REVISION RESPONSE LETTER

RE: 1000, LLC
Site Development Plan
File Number PPR-17-026

DATE: August 24, 2017

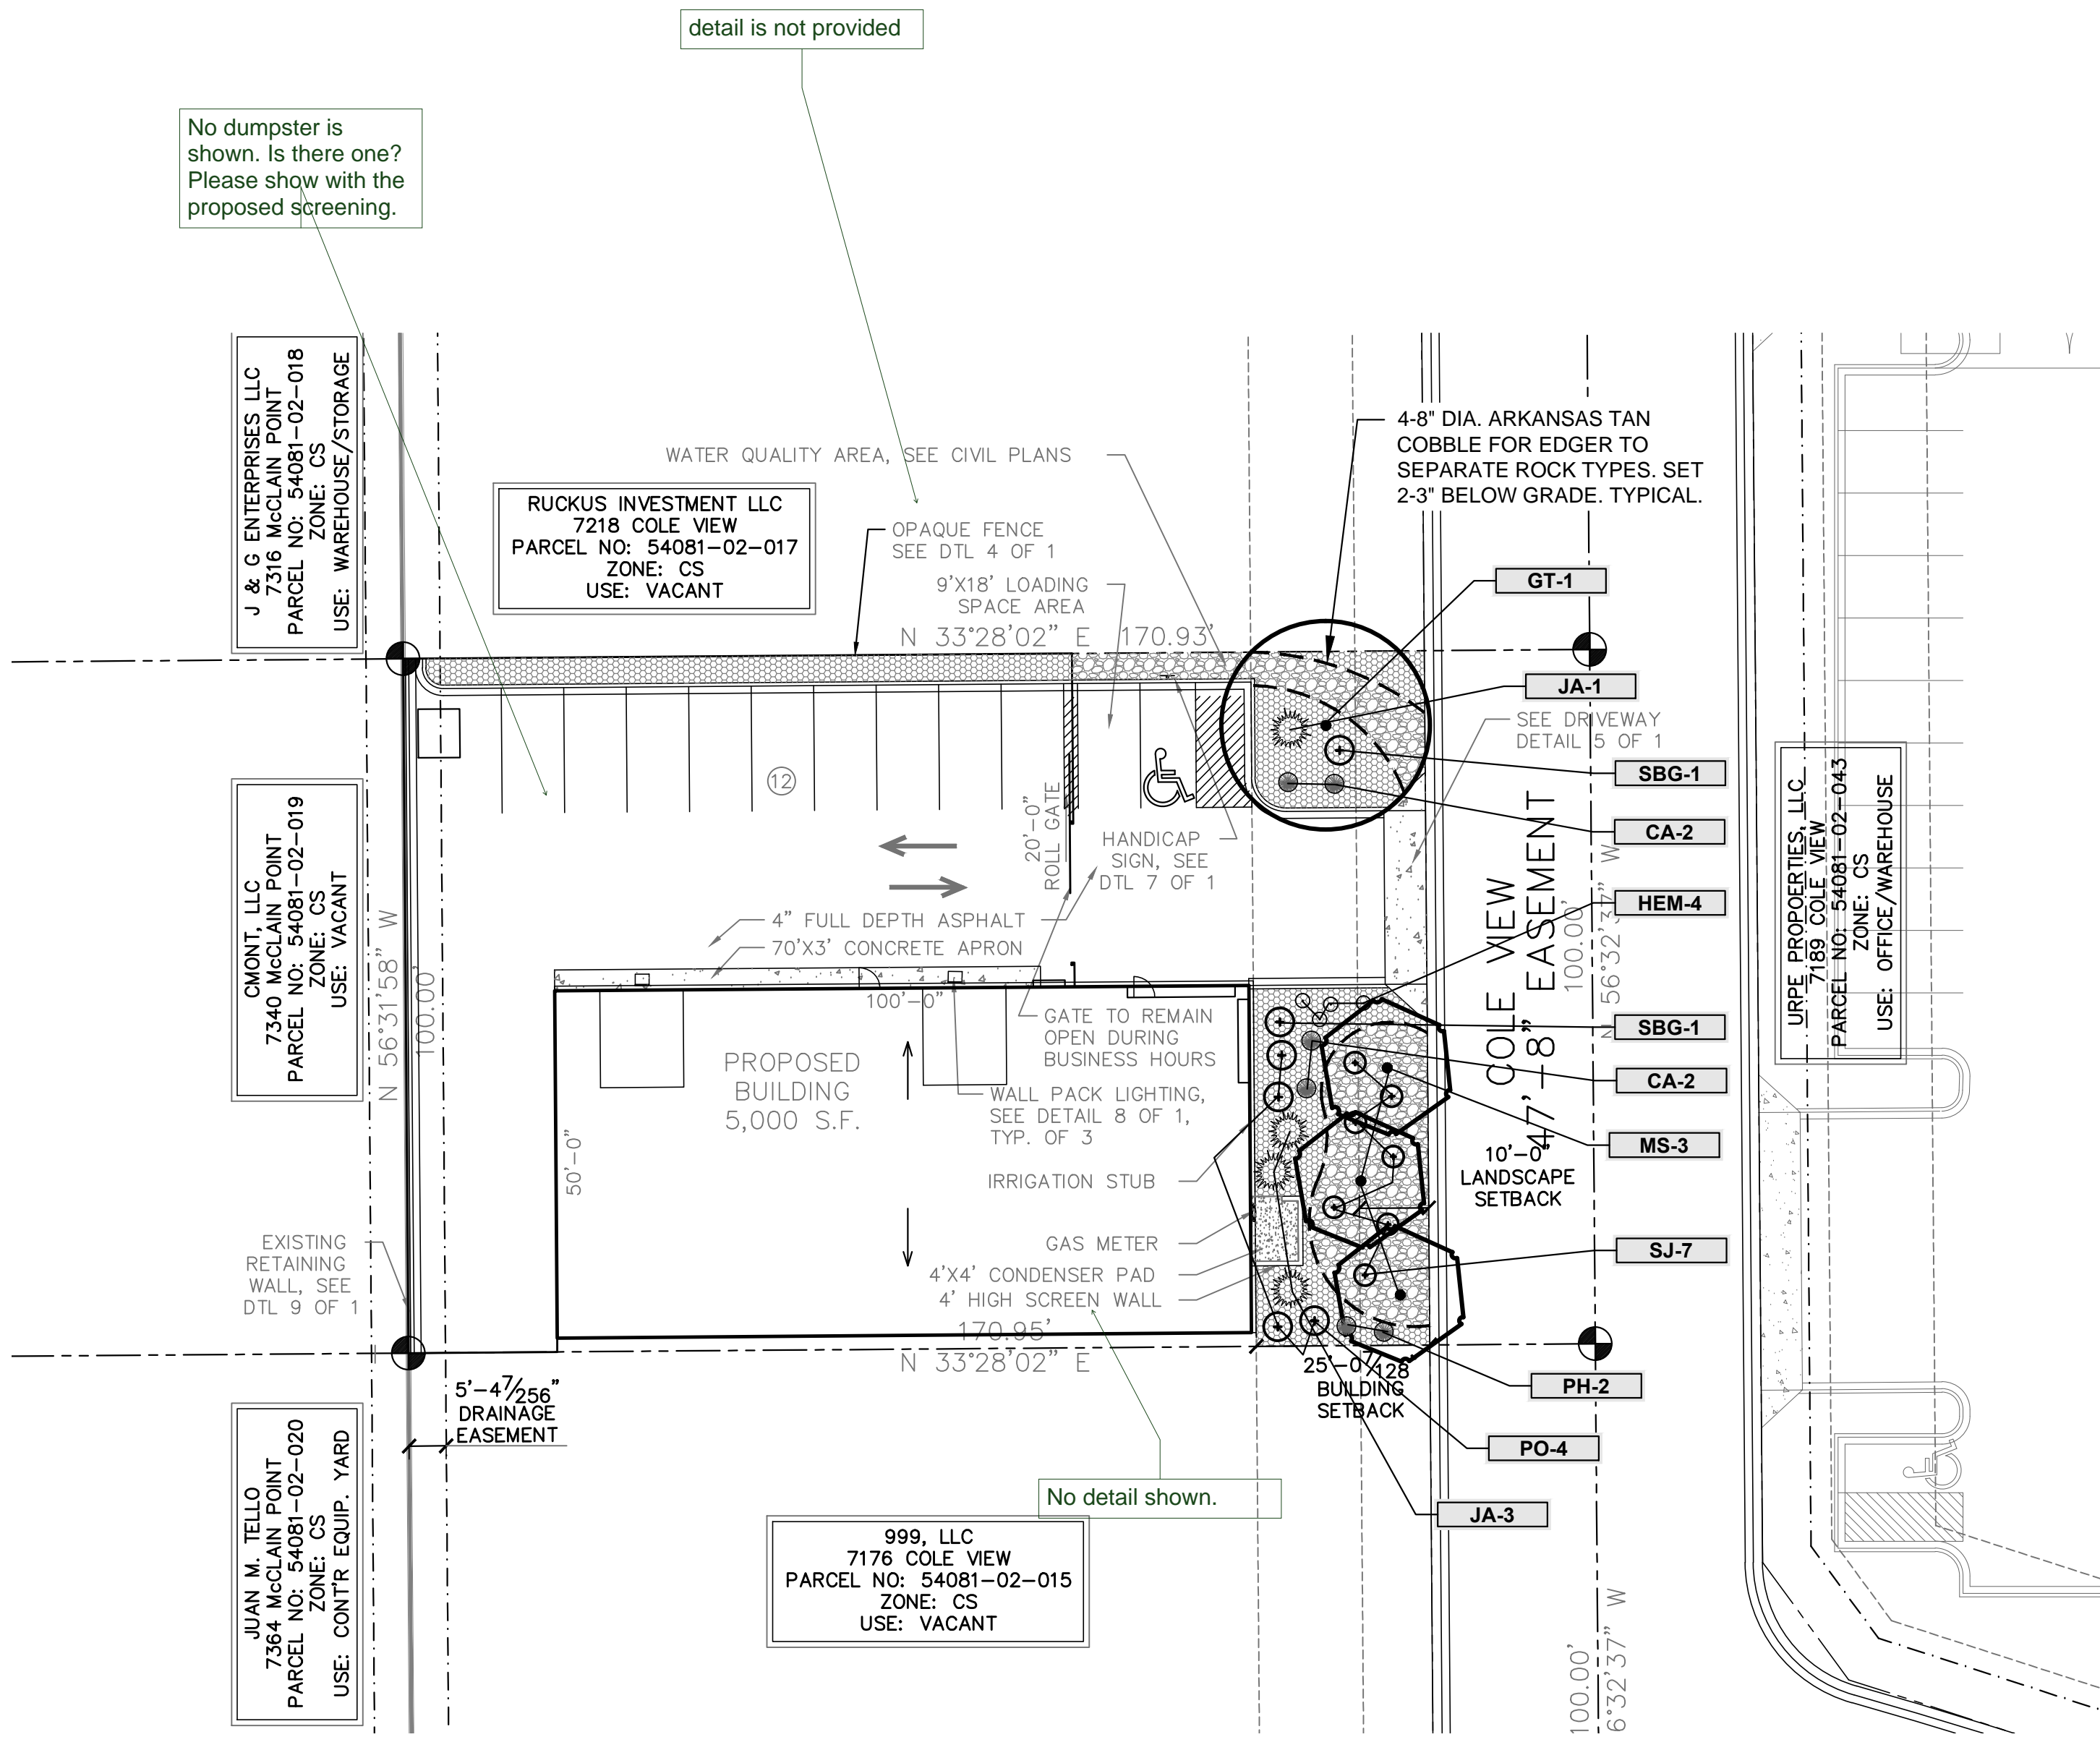
1. Trees should be planted a minimum of 6 feet from electric lines to the base of the tree. **Trees adjusted per CSU comment**
